Ref: 6/2021/2571/FULL
Date: 05/04/2022

HISTORIC BUILDINGS AND CONSERVATION ADVICE

RE: *Judges, Judge's Hill, Northaw, Potters Bar, EN6 4NL*

The application is for the erection of a single storey building to rear for use as additional dining space for existing restaurant.

1 Judges Hill, Northaw, Potters Bar EN6 4NL  
**GROUND FLOOR PLAN & SITE PLAN**

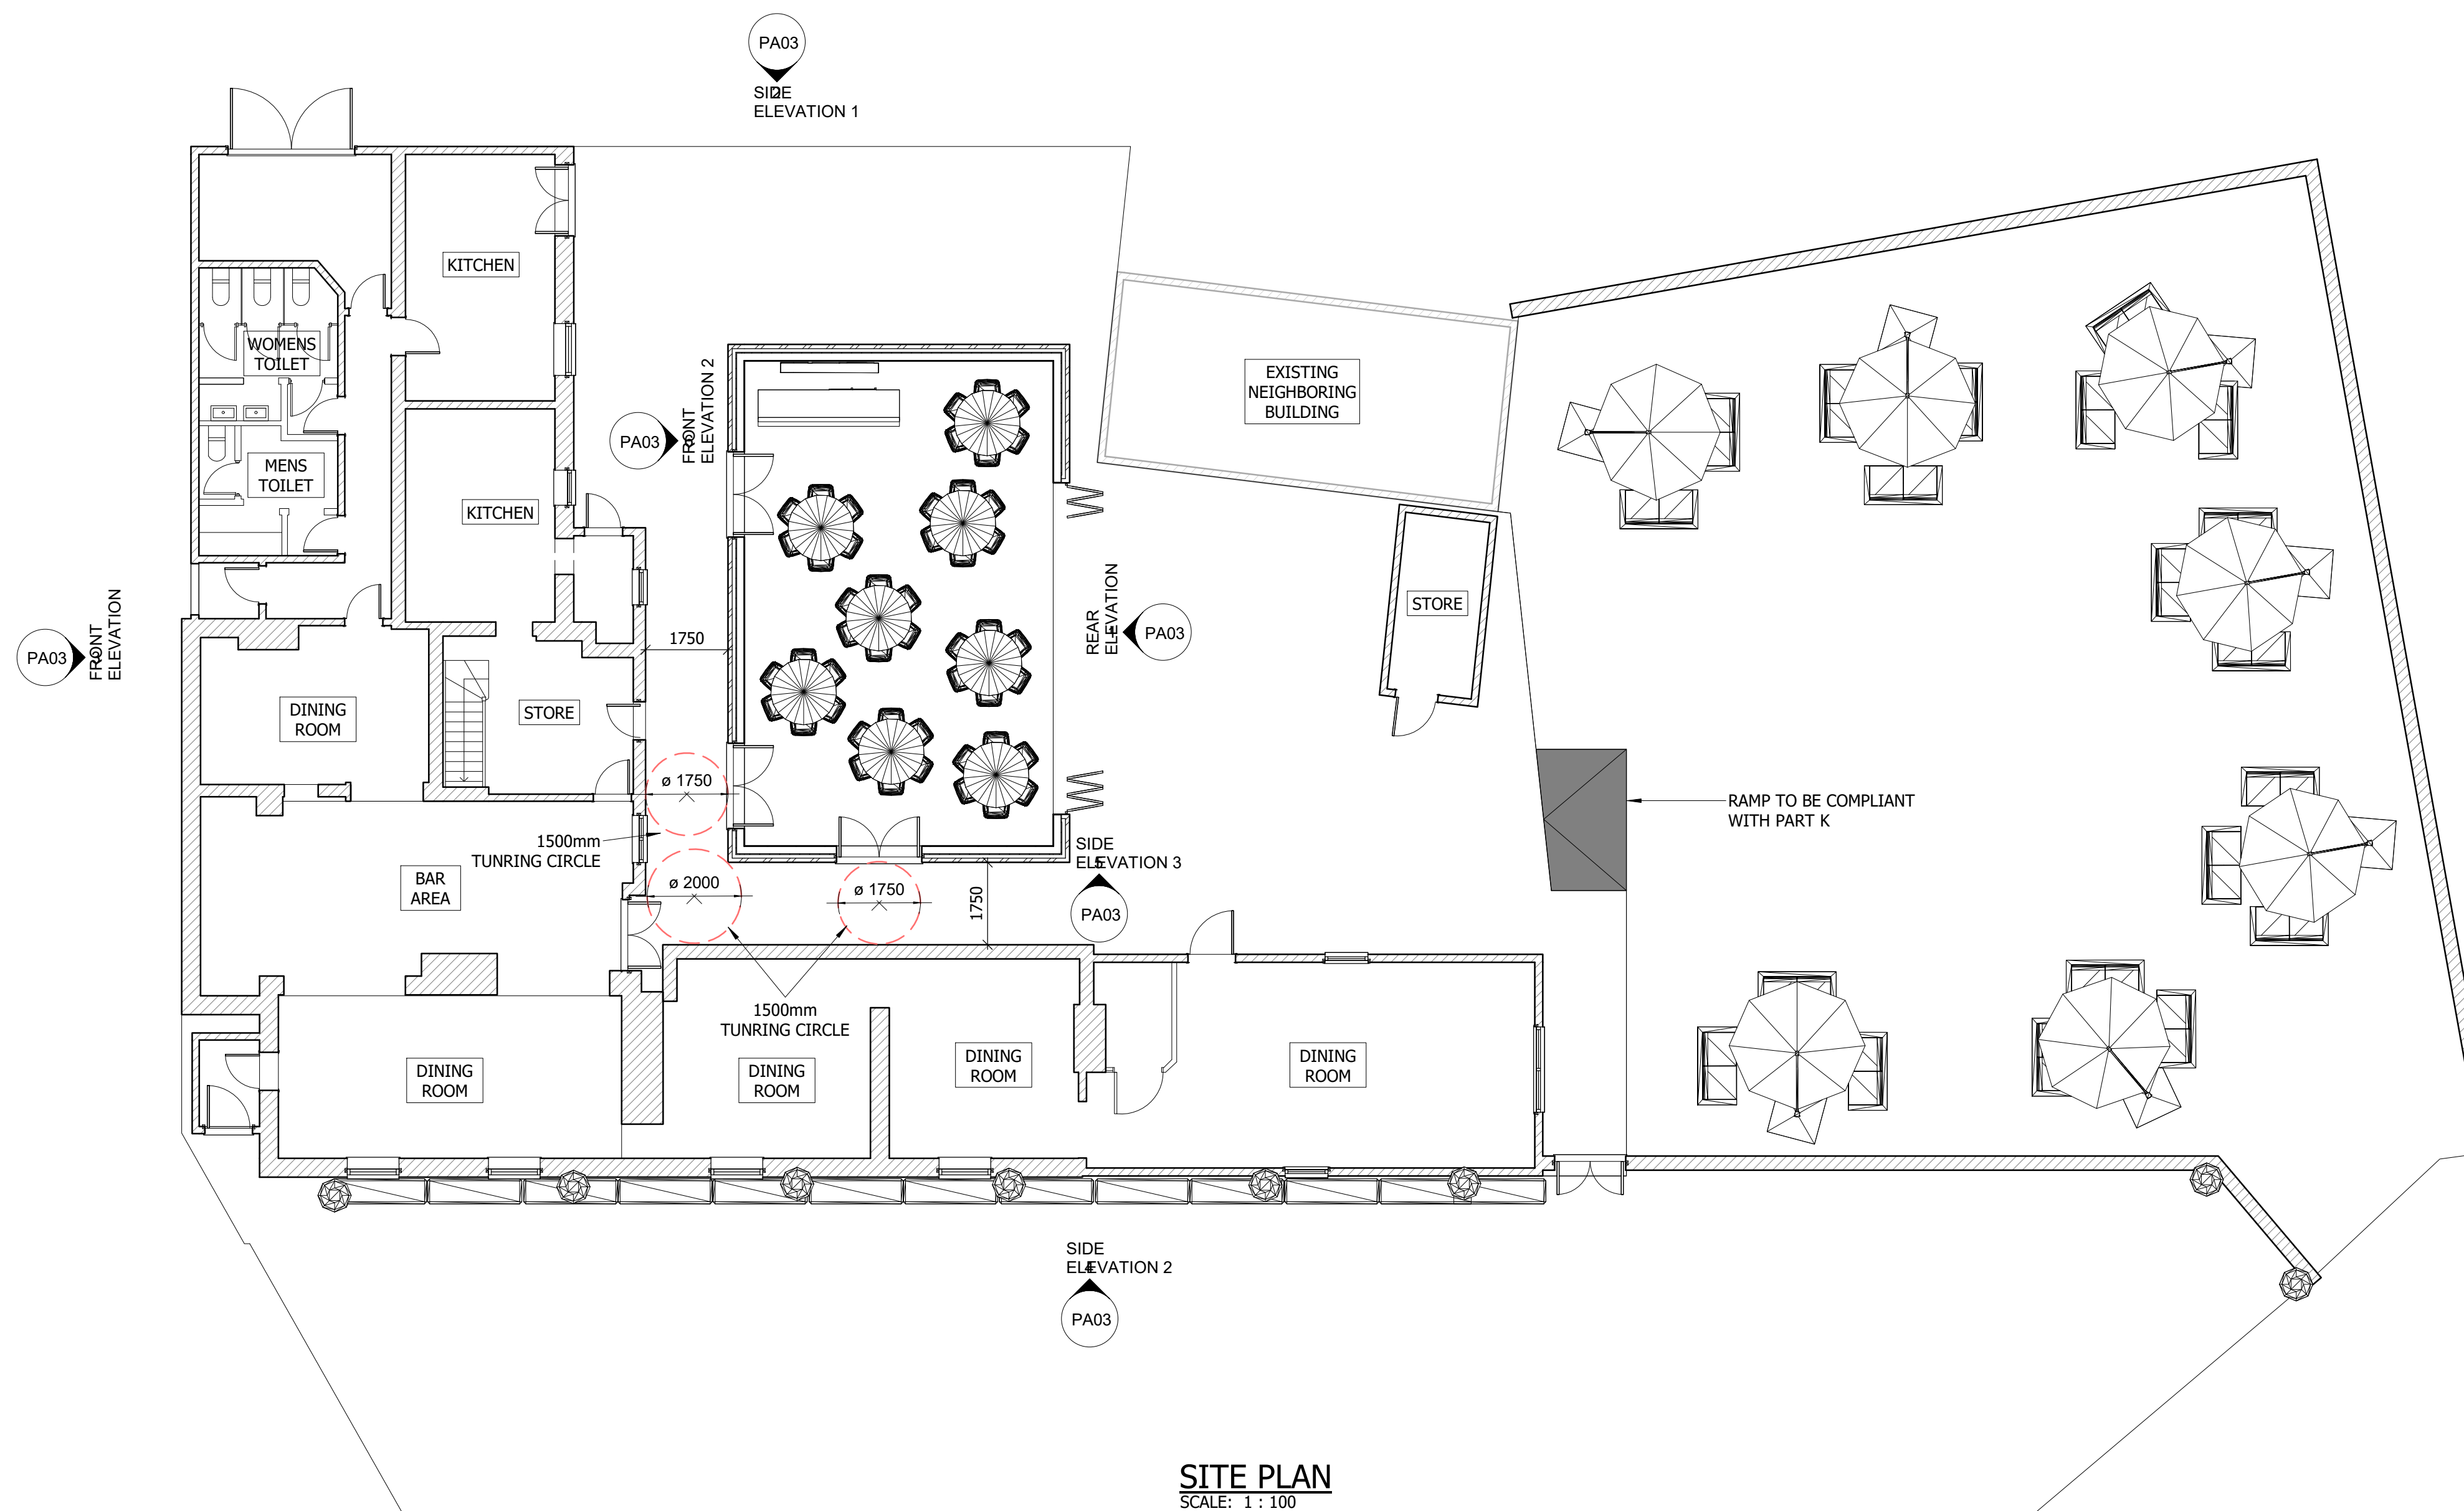
An objection is raised as the proposed building is considered to be detrimental to the setting of the listed building and harmful to its significance. The scale of the proposed building and its proximity to the listed building are unsympathetic to its special interest. It will dominate the rear elevation of the building and, despite being freestanding, will appear as a large extension due to its proximity to the building and the infilling of the space between the listed building and other existing outbuildings to the rear. Furthermore, the large bi-fold doors and rooflights do not respond to the character of the listed building.

**1 Judges Hill, Northaw, Potters Bar EN6 4NL**  
**PROPOSED ELEVATIONS**

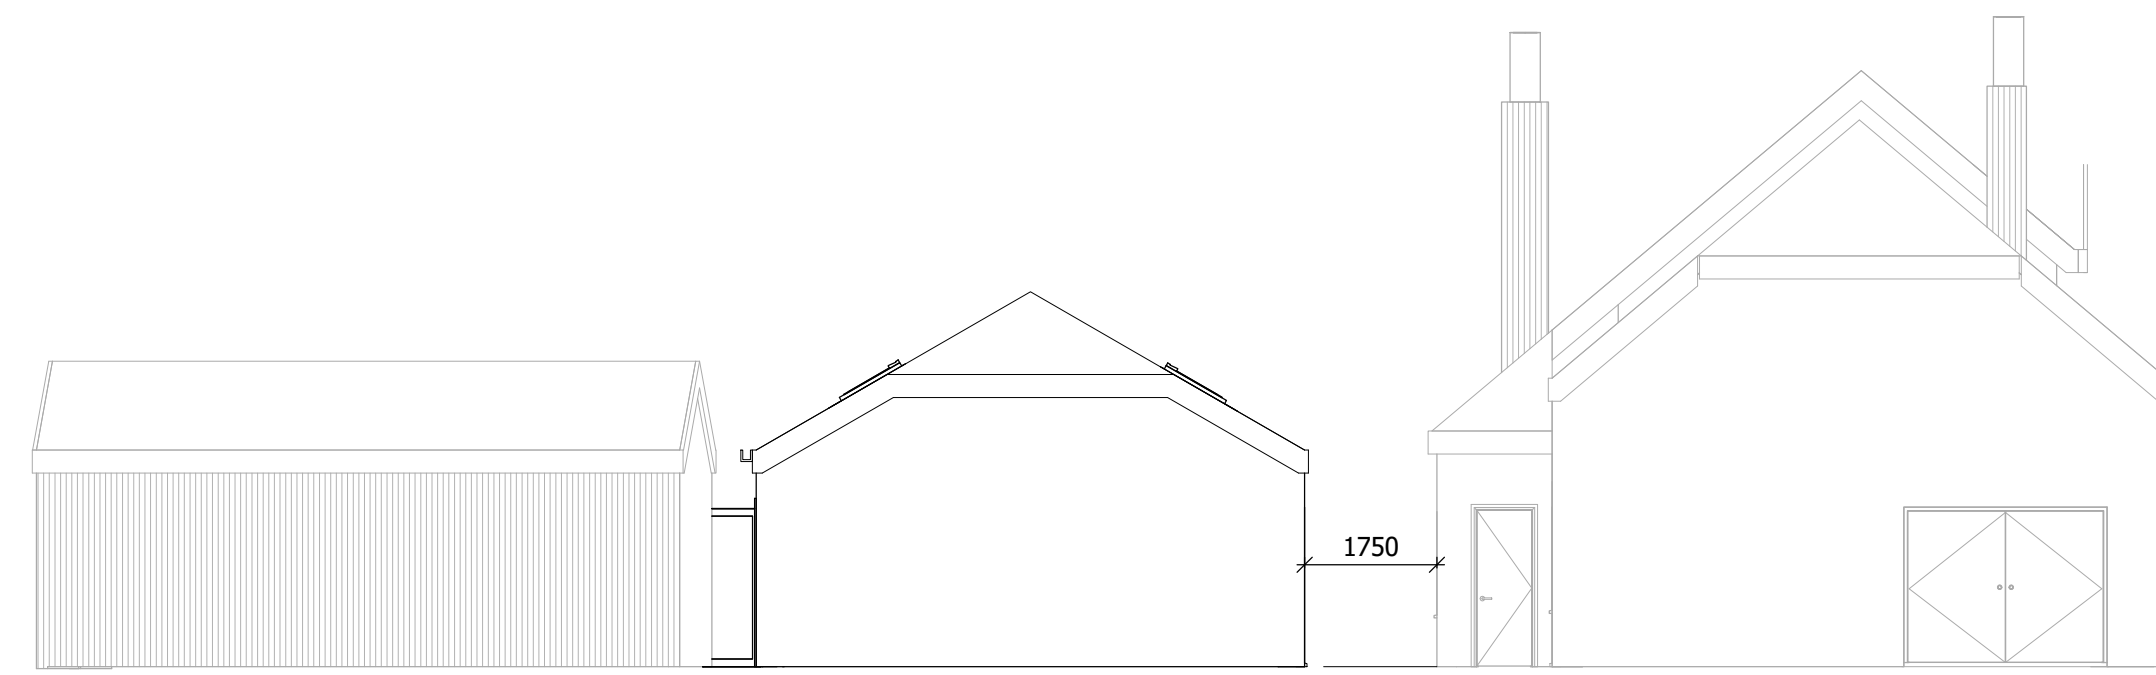
This application follows the serving of a Listed Building Enforcement Notice (upheld at appeal PP/C1950/F/19/3243041) for the removal of a covered seating area at the rear of the building. It is proposed to replace this with a detached single storey building immediately adjacent to the rear of the listed building with a hipped roof and rendered elevations to match the main building.
